STIP No. A-0009CC

Concurrence Point 4B, Hydraulic Design Review Meeting Minutes

Purpose: The purpose of the meeting was to review and discuss the 30% drainage plans for STIP A-0009CC. The limits of the A-0009 CC Section are NC 143 from 0.5 miles north of the Appalachian Trail to NC 28 and NC 28 from NC 143 to 0.2 miles west of SR 1235 (Gunters Gap Road) for a length of approximately 4.0 miles.

PIPE HYDRAULIC DATA
*4108-Y2- Sta. 50+28

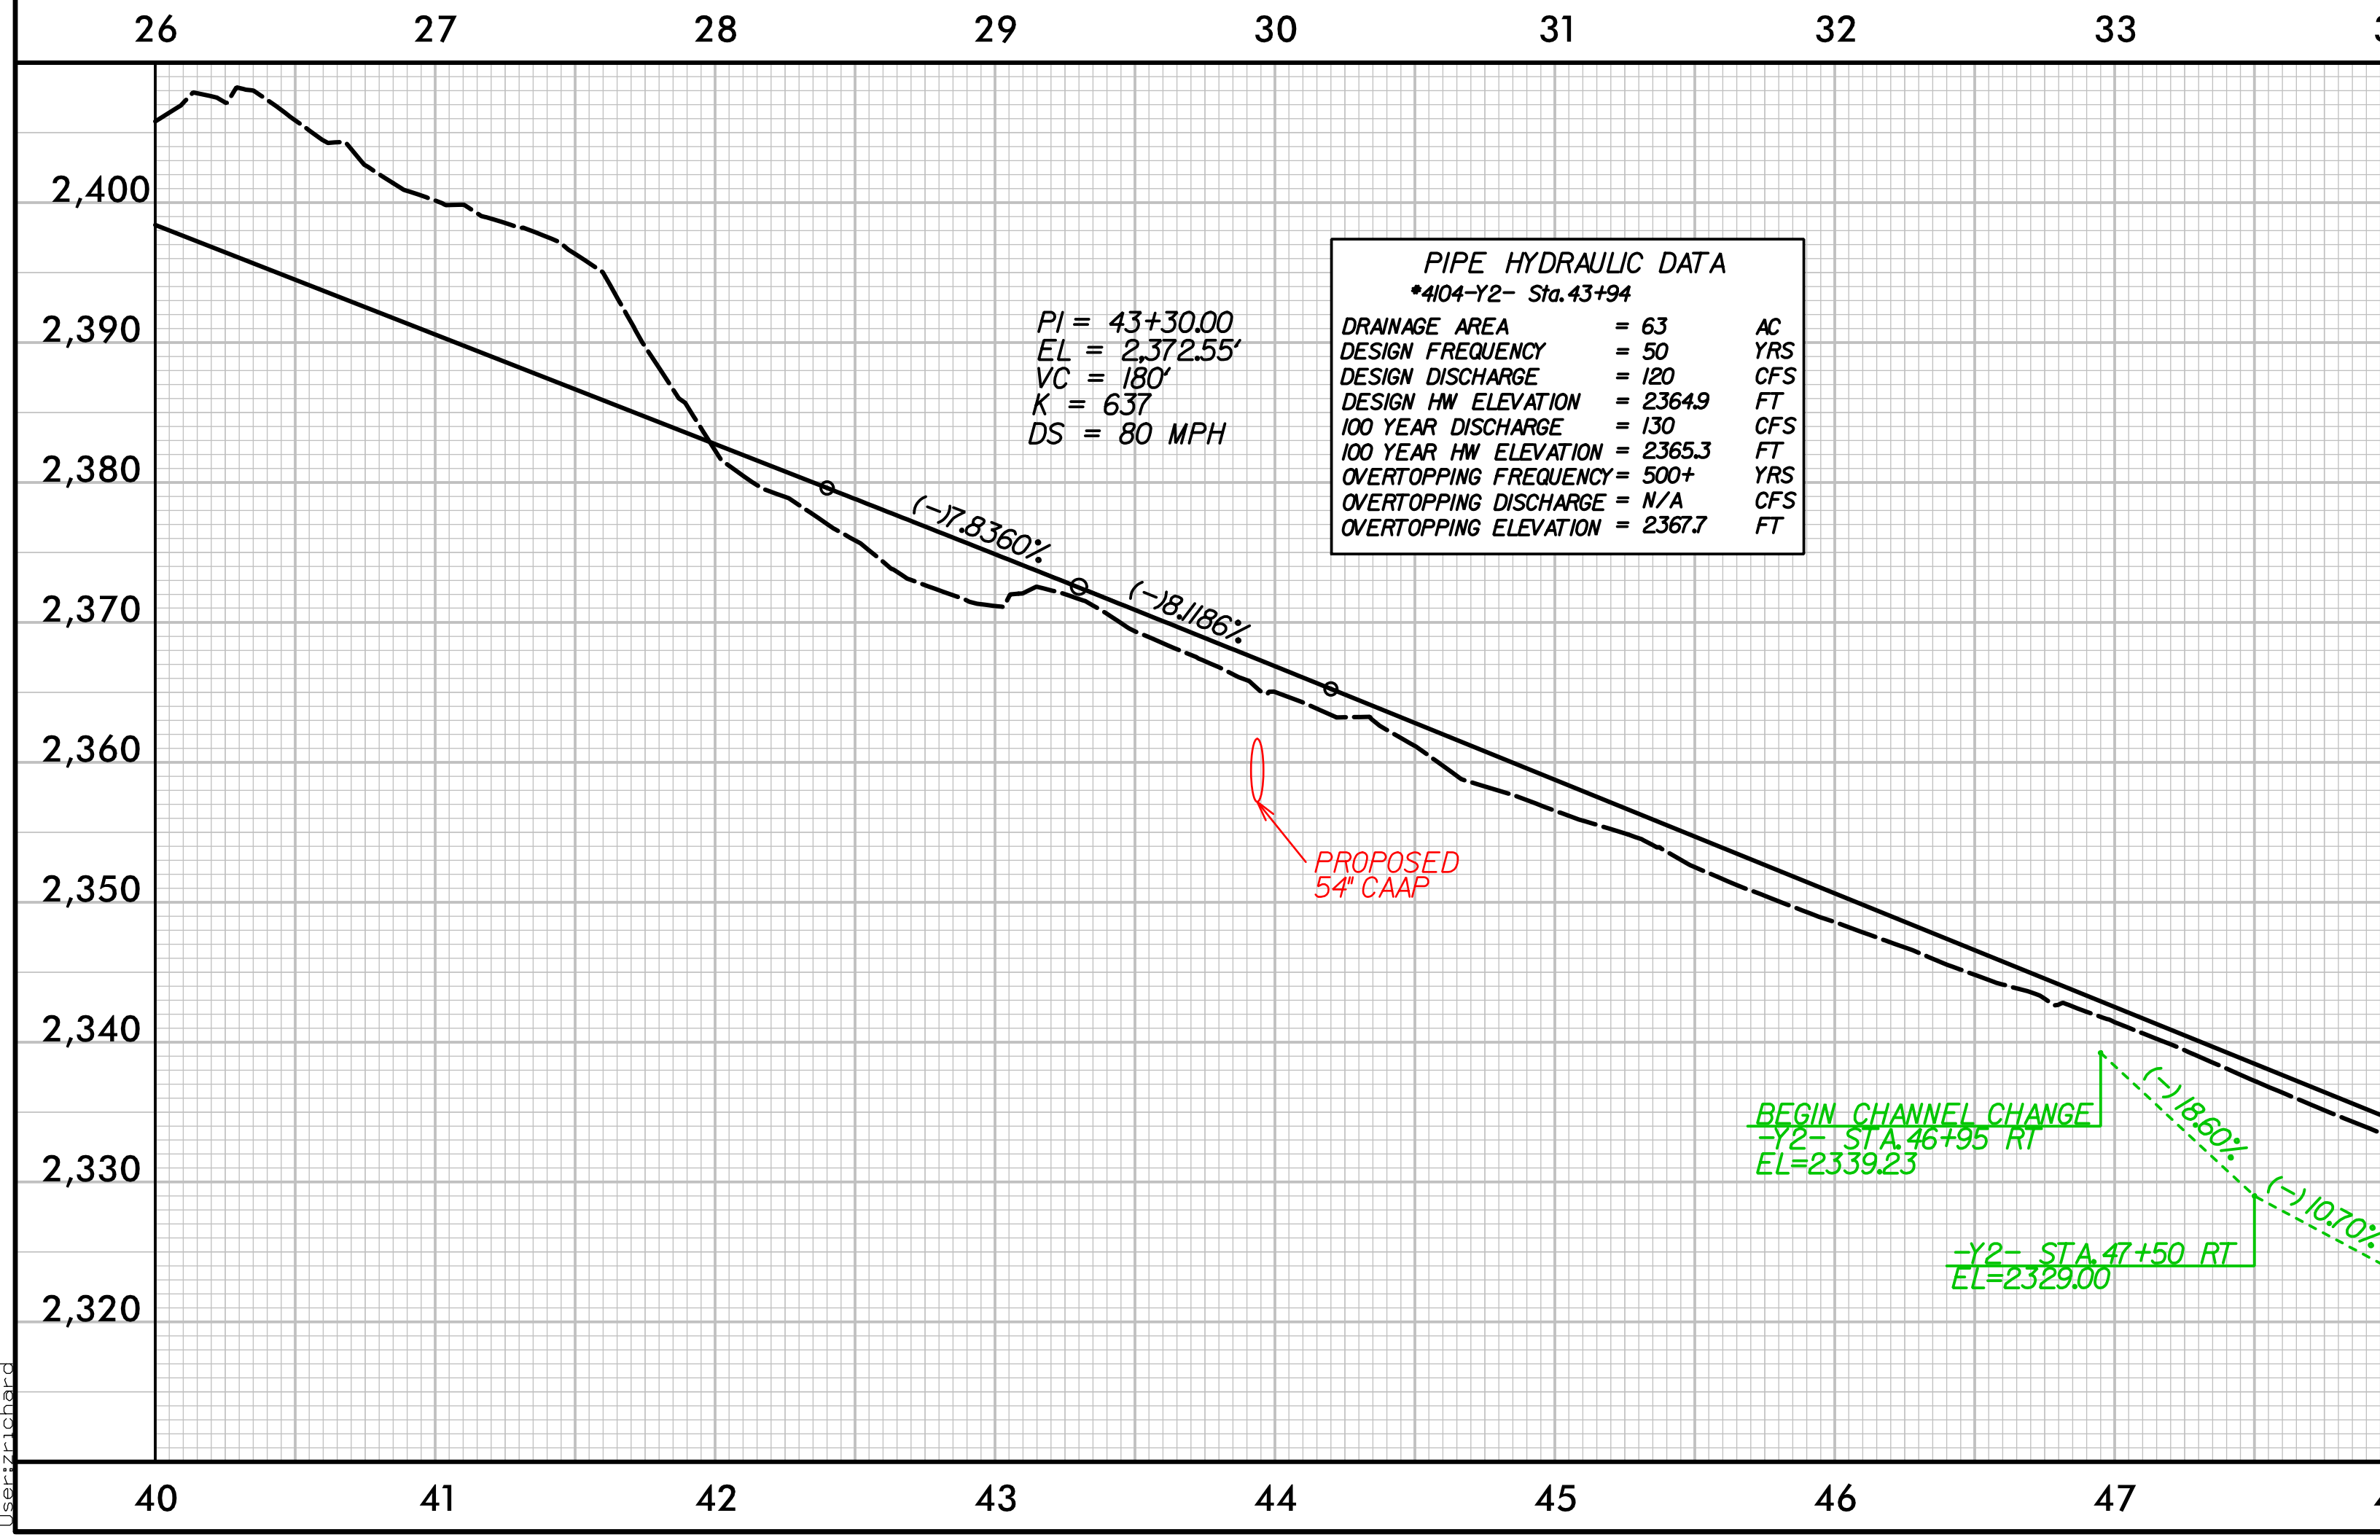
Stream "SFH" (C), perennial, on -Y2- at Station 49+00 to Station 53+00 LT

- Stream is approximately 4- to 6-feet wide on a 16-22% slope upstream and 5-feet wide on a 12-16% slope downstream. The existing 42-inch CSP will be retained and relined with CIPP on a 14% slope and extended with a 48-inch CSP on a 10% slope upstream and a 42-inch CSP on a 18% slope downstream. Downstream, the proposed channel change will be on a 6-15% slope and lined with Class II Rip-Rap for stability.
 - NCDWR asked if consideration was given to build retaining walls in this area
 - TGS confirmed this curve is at the minimum radius to satisfy design speed and is set to save several homes and removal of an access road at Station 39+00 LT which serves numerous properties. A retaining wall option was evaluated; but much of the stream would still be impacted plus a channel change was still required which made the retaining wall option not feasible due to impacts.

- NCDWR stated that they understood the justification for not placing a wall upstream but there is more room downstream, so asked why not build a wall downstream. Stated could present findings at CP 4C if the Team need time to evaluate.
 - USACE concurred
- USACE reminded the Team that to lower the mitigation rate you must follow the stream relocation guidance. Mitigation is going to depend on how this stream looks compared to the current stream. Anything that the Team can do to improve the stream or bring it back to where it is now or better will help with mitigation
- NCDOT asked will the larger Class II Rip-Rap bury the stream flow in the channel change.
 - TGS stated that it is proposed to be lined due to the steepness and that any proposed Rip-Rap would be keyed in
